Re: ***Eagle Rising (SF2225) - Responses to 8/15/24 Final Drainage Report Comments***
MVE Project No. 61145

The Final Drainage Report (FDR) for the above named project has been revised to address the latest set of comments review. This letter contains engineer responses to the comments referenced by pdf page number.

EAGLE RISING FILING NO. 1
 A PORTION OF THE EAST HALF (E1/2) OF SECTION 29, TOWNSHIP 12 SOUTH,
 RANGE 65 WEST OF THE SIXTH PRINCIPAL MERIDIAN, EL PASO COUNTY, COLORADO

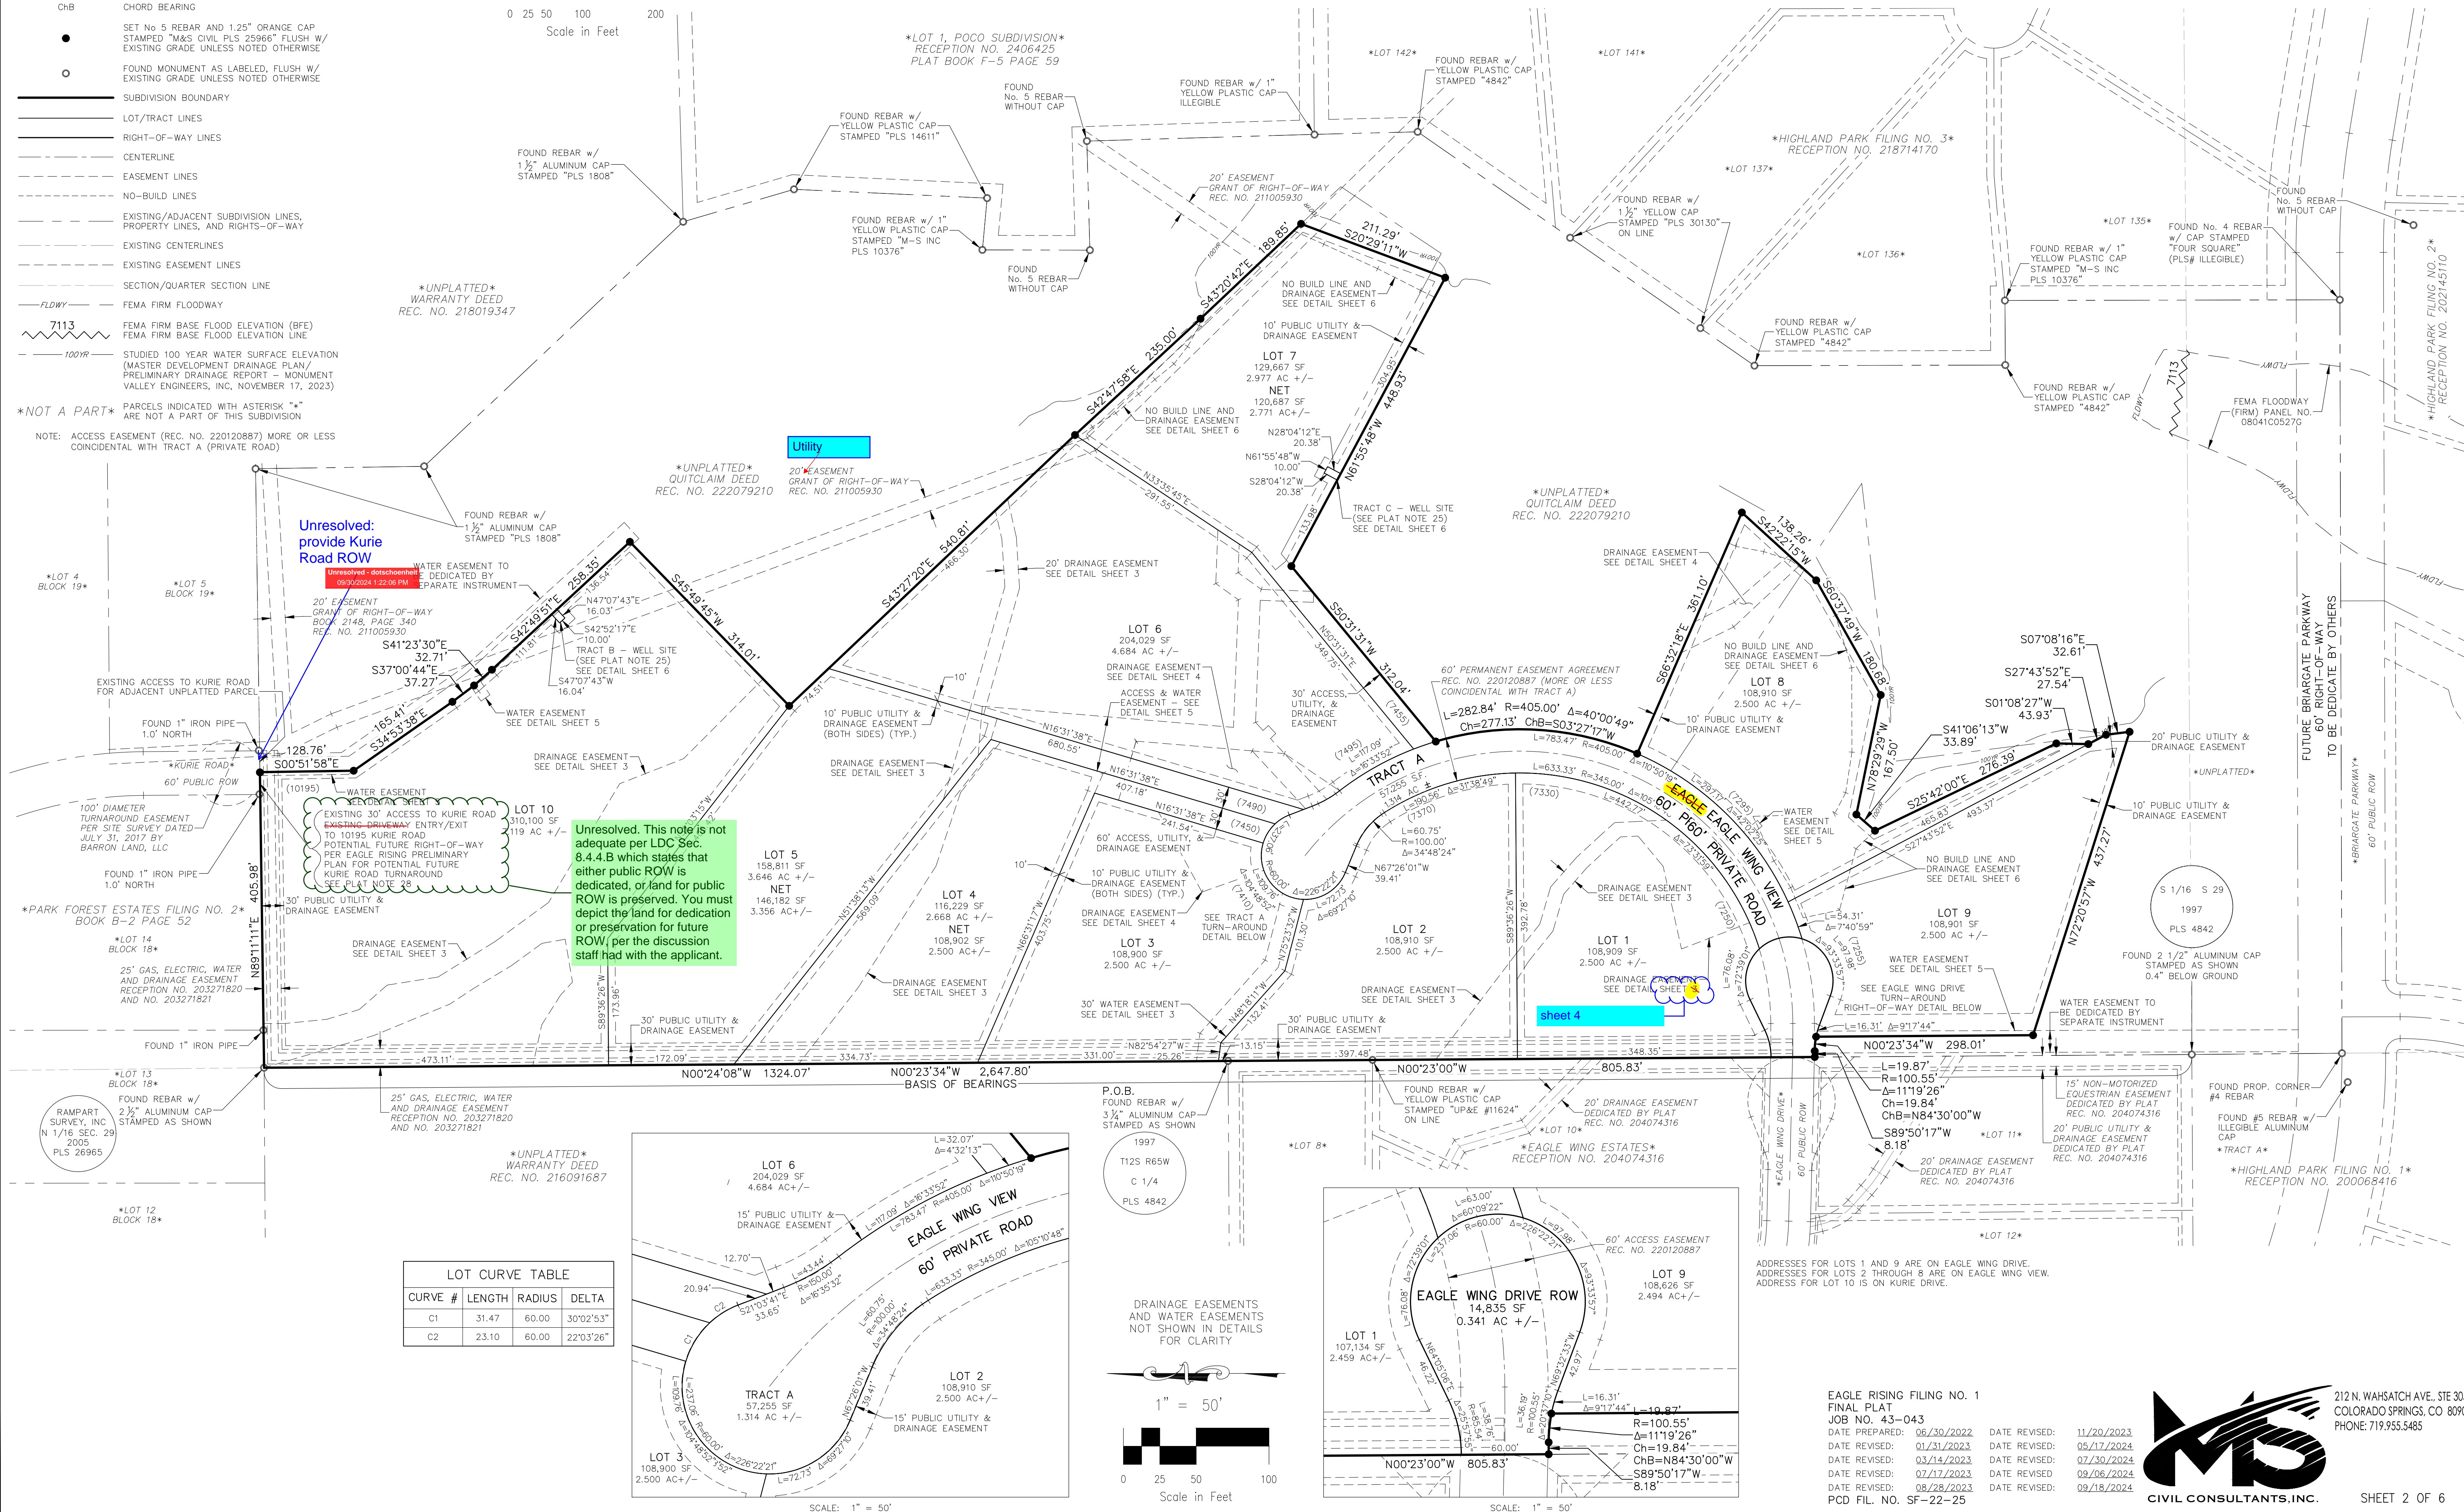
211	DP7, DP9 & DP10 flows highlighted	DP7, DP9 & DP10 flows have been updated.
211	“Analysis should be based on conditions before redirected flow per previous version”	The revised flow path/basin connectivity on this map is the corrected existing condition. No change back to the previous version is needed.
212	“Unresolved: Adjust plat and plans to show the cul-de-sac ROW	Owners discussions with the Planning Director continue. The owner has not authorized new cul-de-sac R.O.W. to be shown.
212	“label pipe”	The pipes are labeled with #CLVRT# along with leadered note having pipe size
212	“water still flows here - provide 2 design points or adjust F2”	Adjusted Basin F2 to include the area which drains through, eliminating the need for a new design point.
212	“Unresolved: Provide drainage easement”	Added Drainage easement and coordinated with plat drawing
212	“Provide drainage easement and analysis based on revisions to report”	Added Drainage easement and coordinated with plat drawing
